2 September 2016

Re: Response to CPTED matters for the State Significant Development (SSD 15_7237) for Arthur Phillip High School and Parramatta Public School

DRAWING
SITE PLANS CONTEXT PLAN
PROPOSED & DEMOLITION

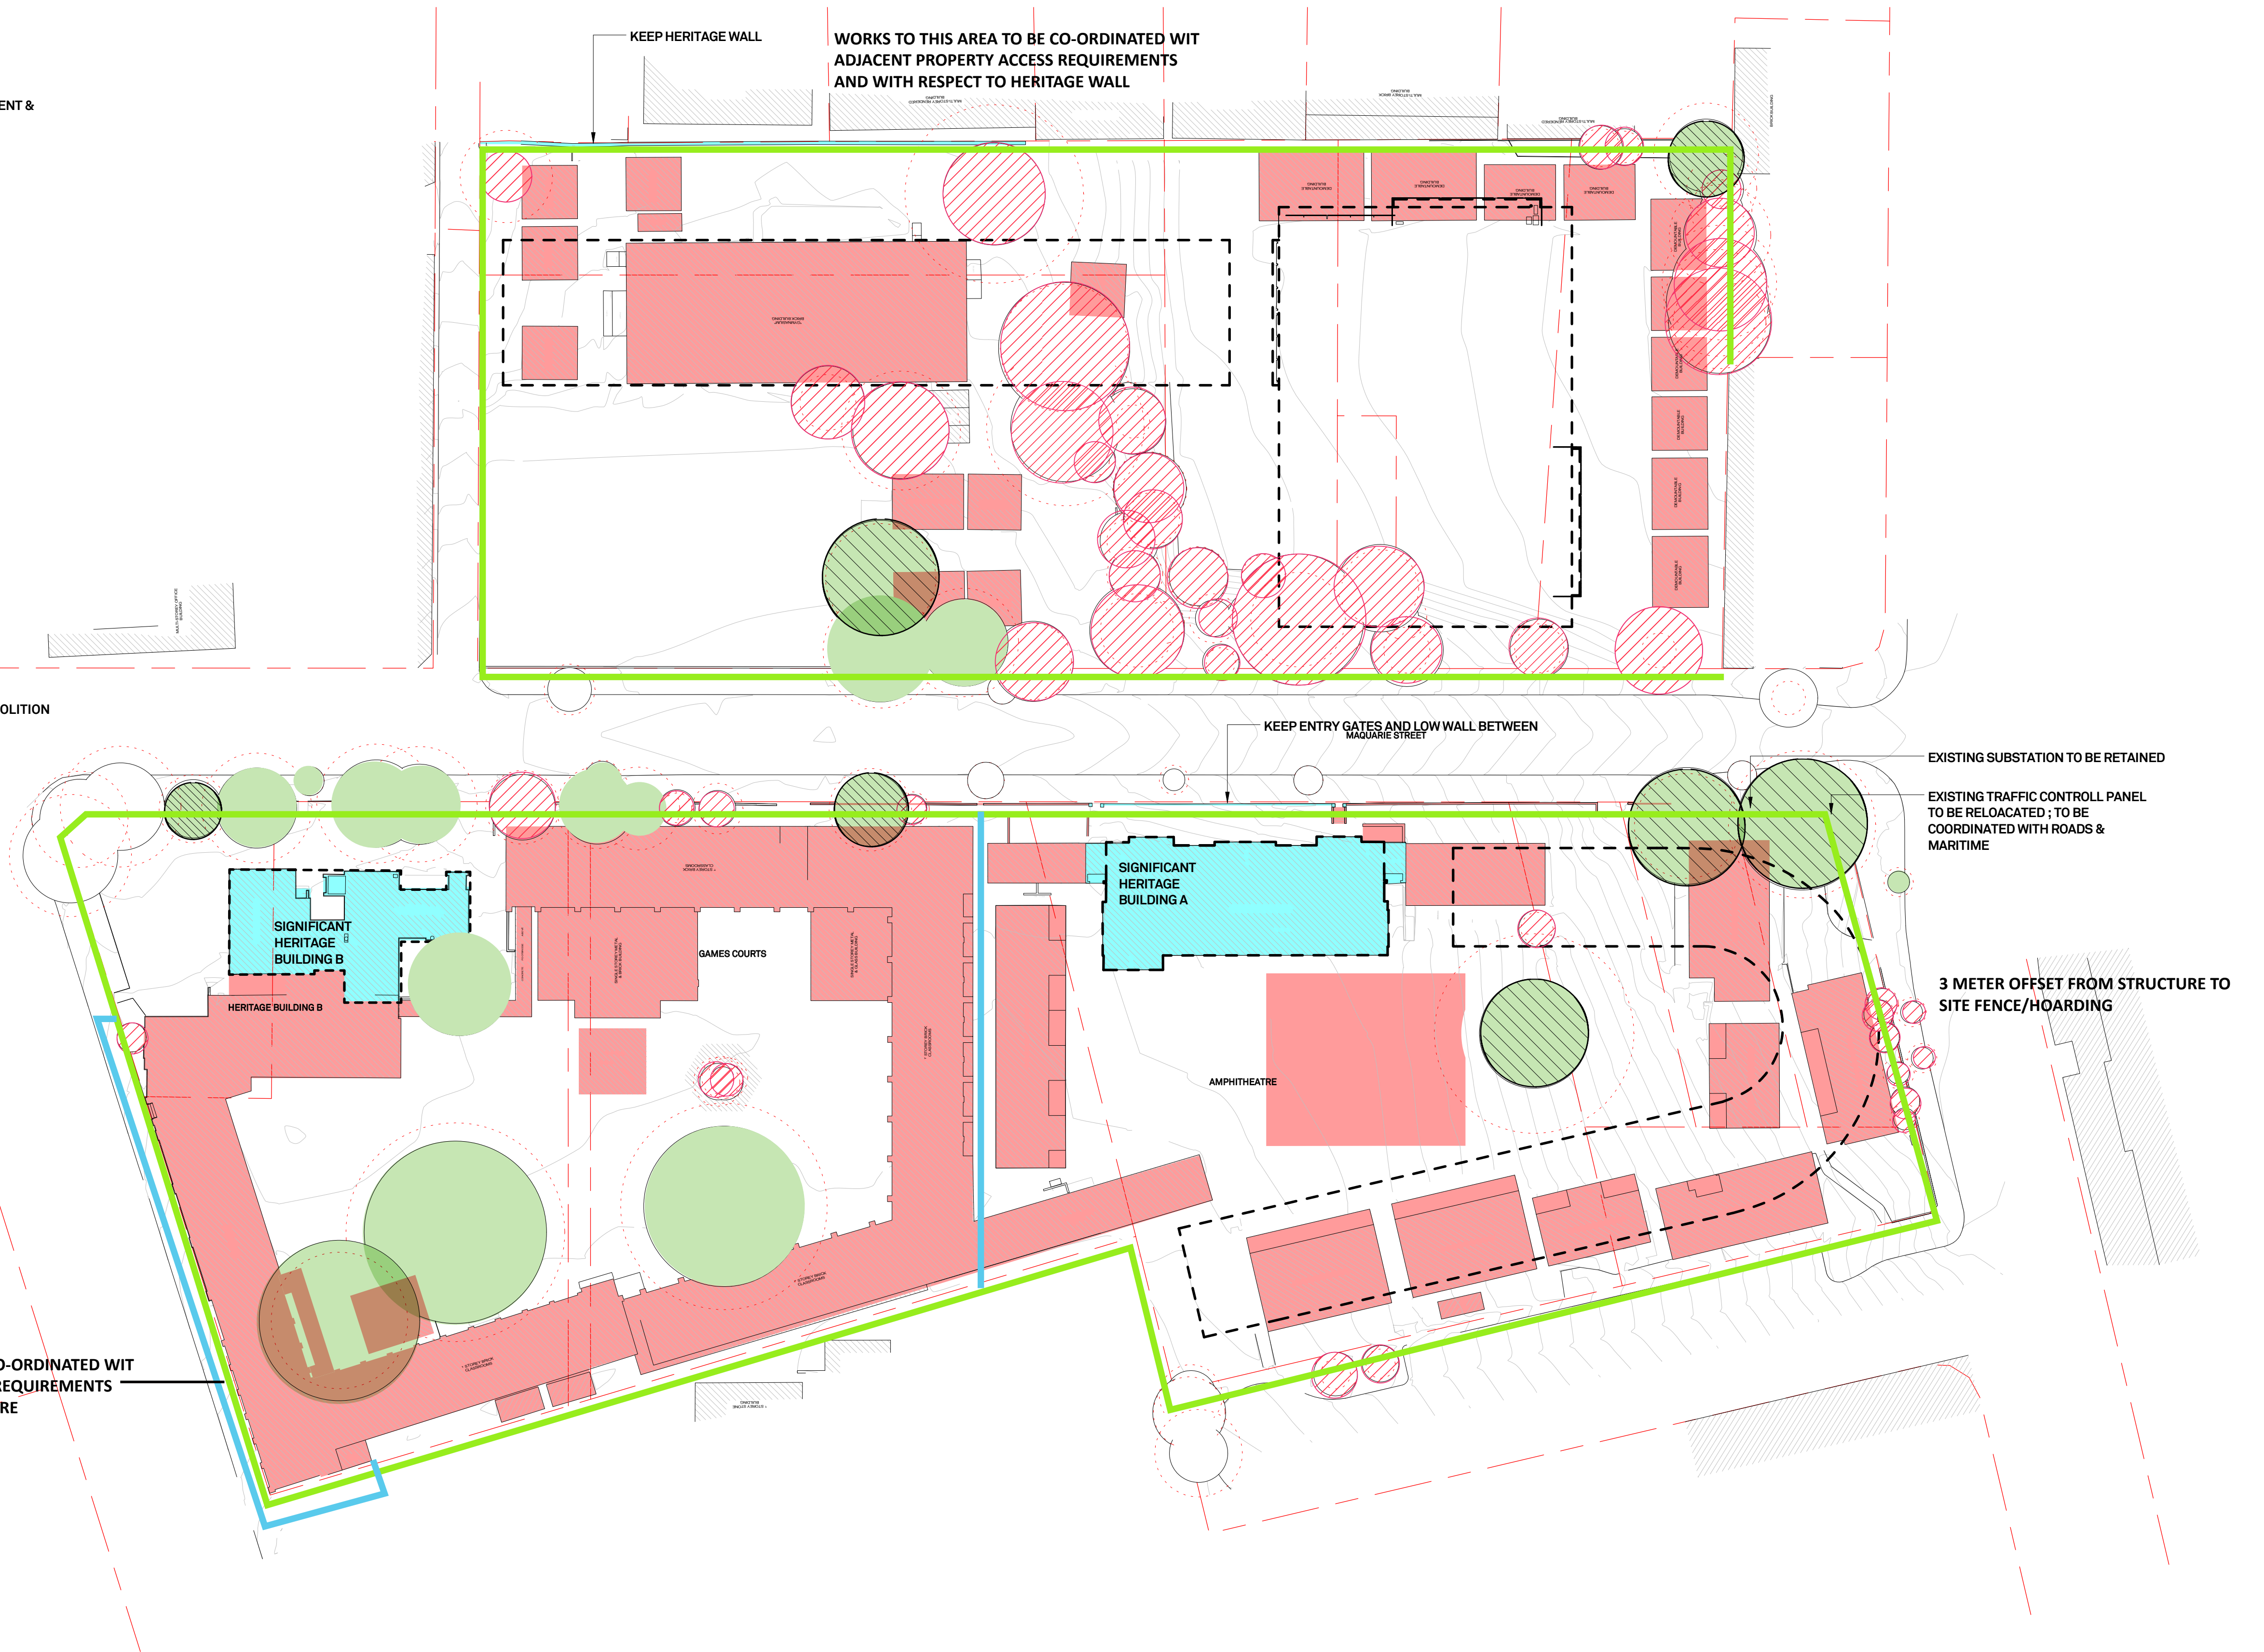
In regards to security concerns associated with the proposed development in close proximity to Lancer Barracks, the Defence suggests that the applicant incorporates CPTED measures into the design of the proposed development and these measures are implemented throughout the built form to minimise opportunities for criminal activity.

The neighbor raised concerns that there will be a higher number of pedestrians in area which will impact upon the safety of the Lancer Barracks. In particular, the neighbor raised concerns about the pathway linking Little Street and Smith Street which will be exposed at times. The neighbour also raised concerns about vandalism.

In accordance with this principle, the development provides for good natural surveillance opportunities to the Lancer Barracks. The PPS site currently has buildings along its southern elevation which restricts passive surveillance to Lancer Barracks. The proposal seeks to remove these buildings and replace them with active play areas and a through site link from Smith Street to Little Street. The active play areas and through site link will create further passive surveillance opportunities to the Lancer Barracks than at present.

The proposed through site link will provide clear sightlines and will not provide opportunities for hiding places for offenders to hide or entrap victims. The proposed landscaping and fencing which is open, promotes passive surveillance into Lancer Barracks from the school grounds.

The proposed landscaping and fencing along the southern boundary of the PPS site clearly delineates between the school and through site link while some of the Lancer Barrack buildings define the boundary with the school site. The entry of the through site link will be clearly visible from Smith Street and Little Street and the through site link will be open to the public.

The proposed landscaping and perimeter fencing along the southern boundary of the PPS site clearly identifies the school site and the through site link. Being a sensitive use, it is important that the school maintains effective barriers to prevent unlawful entry, such as fencing, whilst at the same time maintaining good urban amenity.

The landscaping and palisade fencing will prevent vandalism and graffiti while the through site link area will require minimal maintenance. The continued maintenance of the southern elevation of the PPS will ensure that it does not become degraded and will ensure that vandalism of the property is strongly discouraged. Furthermore the school and Department of Education will ensure that a robust maintenance regime is in place for long term building durability and to ensure any required repairs are expeditiously addressed.

In conclusion, the proposed palisade fencing, landscaping and through site link along the southern boundary of the PPS site will encourage passive surveillance while it will clearly define the public and private realm and therefore will not impact upon the safety and security of the Lancer Barracks. Please let me know if you have any issues regarding these matters, I can be contacted on (02) 8667 8668 or lmcmahon@mecone.com.au.
